To: Jordan & Skala Engineers, Inc. RFI #: 34
14240 Midway Road, Suite 350 Date: 1/17/2012
Dallas, TX 75244 Job: ES-02 Keller Springs Lofts
Ph: 480/385-1616 Fax: 480/385-1615 Phone: 877-777-6115

Subject: Fountain Equipment power and panel location

Drawing: E-1.3, E-1.7 Spec Section:
Cost Impact: None Schedule Impact: None

SHEET NUMBER
E-1.3

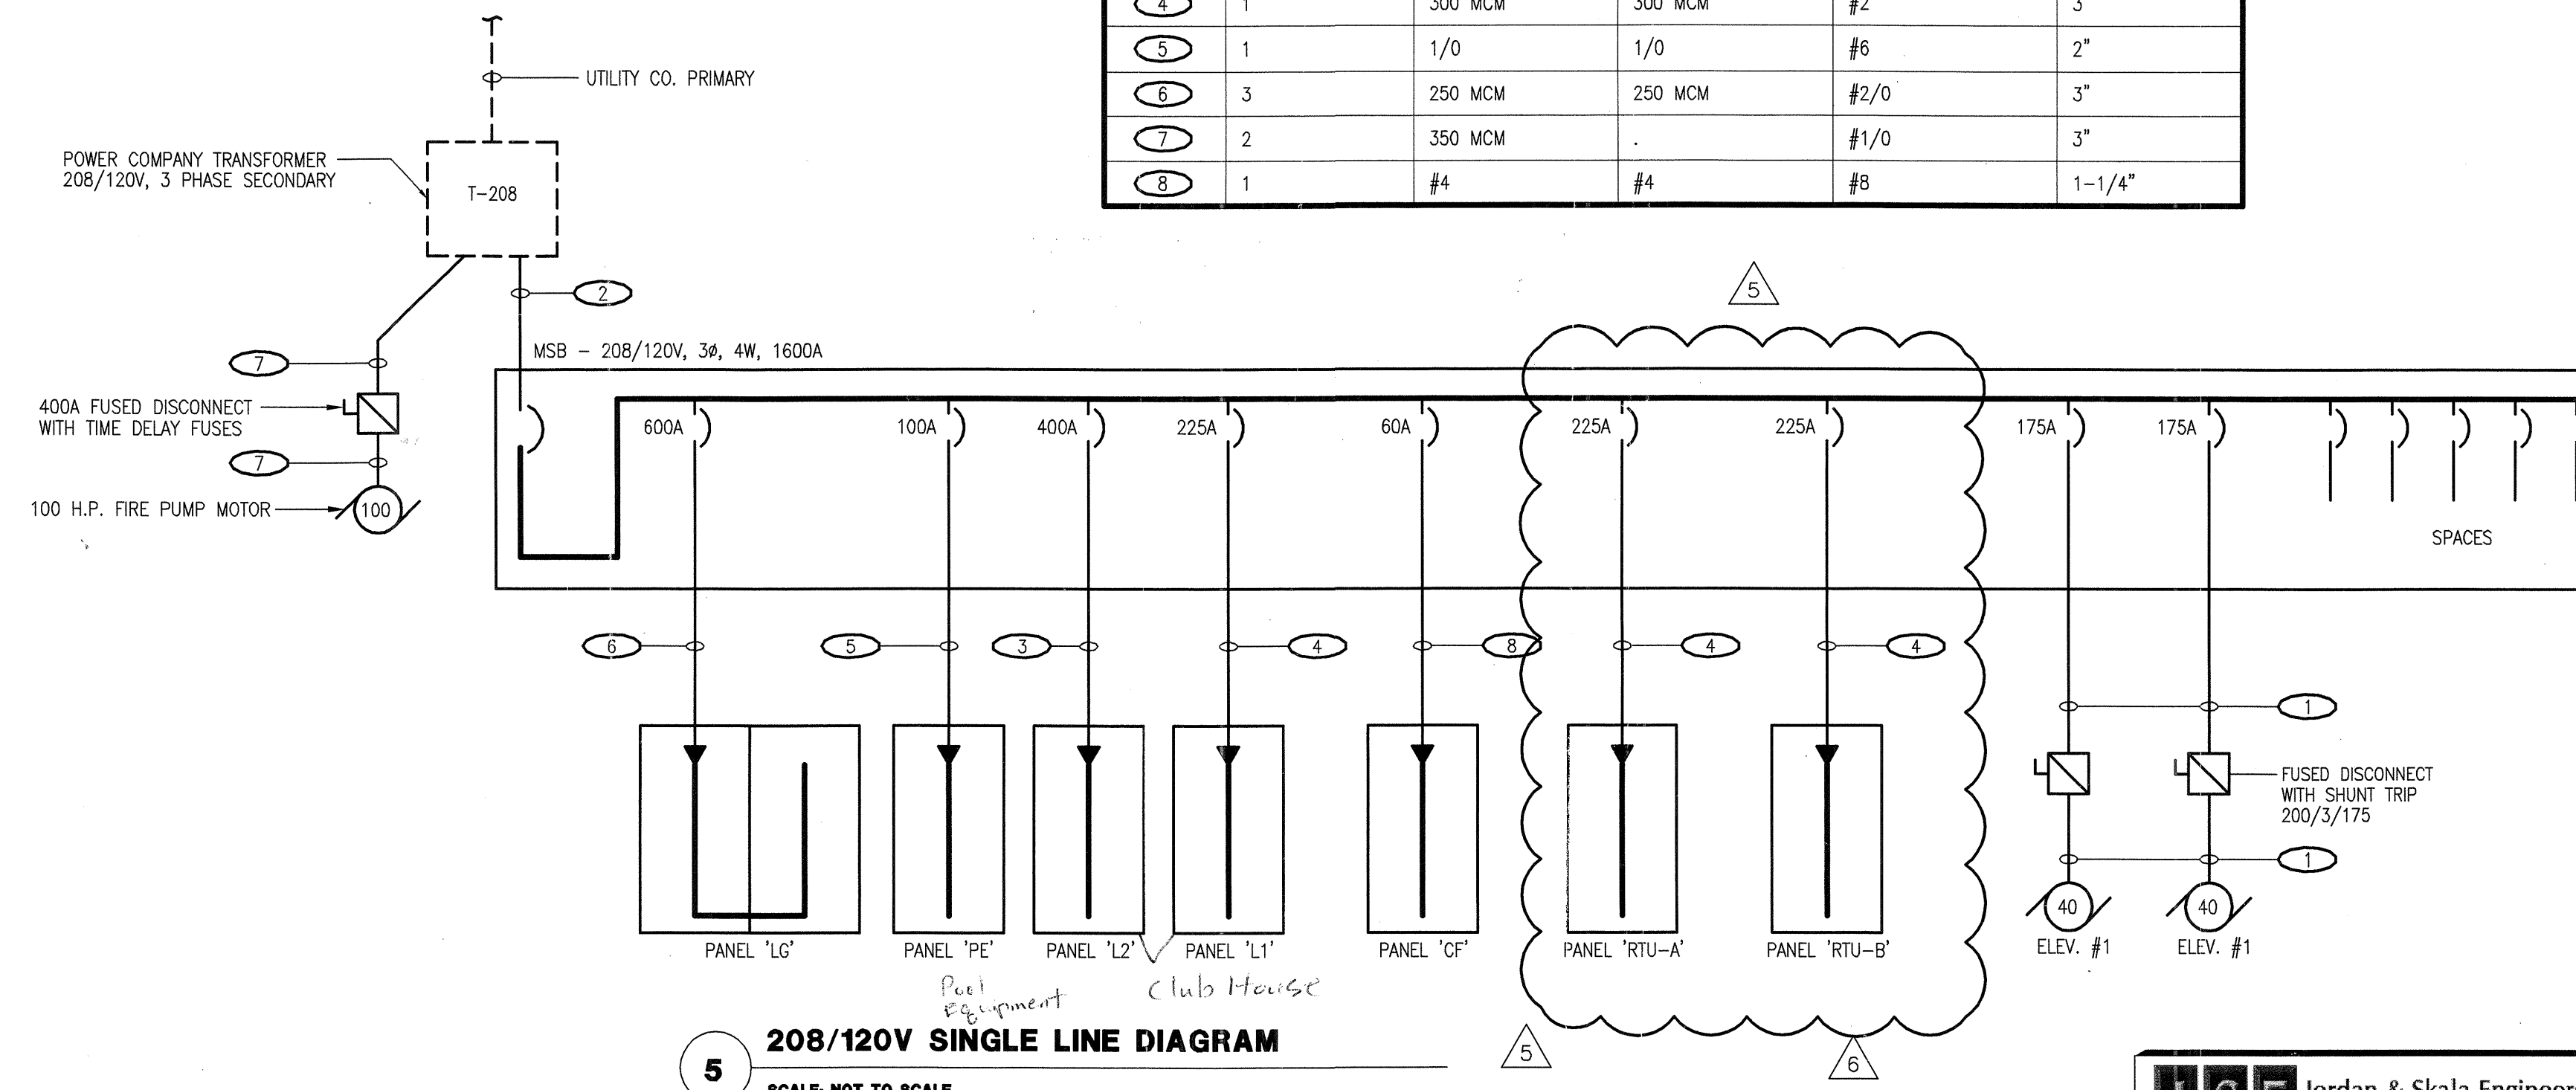
Request: Date Required: 1/24/2012
On sheet E-1.3 on 1/22/11 a Panel 'CP' was added to the panel as a design revision. Is this for the fountain courtyard including the fountain equipment?
Sheet E-1.7 Panelboard schedule 'CP' has a note for contractor to coordinate with landscape and architect on location of 'CP' Panel. In talking with my electrician and pool contractor, we all feel the location for the CP panel should be located at the pop-out area in building between the patio's located to the southeast of the fountain equipment vault, which would be about 14' away from the power. By locating this panel in the courtyard, it would make any future changes or additions for the power requirements to the courtyard readily available.
Requested by: Bryan Pichler
Embrey Partners, Ltd.

Response: We are fine with the proposed location of the electric panel. We do have a proposed Japanese Yew that will be in conflict with the panel, so we recommend not installing the Japanese Yew and just filling the area in with Litrope groundcover.

JSE Response: Panel 'CP' serves the fountain courtyard and the fountain equipment.

Relocating the panel as noted by Enviro Design is acceptable.
- Mike Jennings/Heath Parnell, Jordan & Skala 2/6/2012
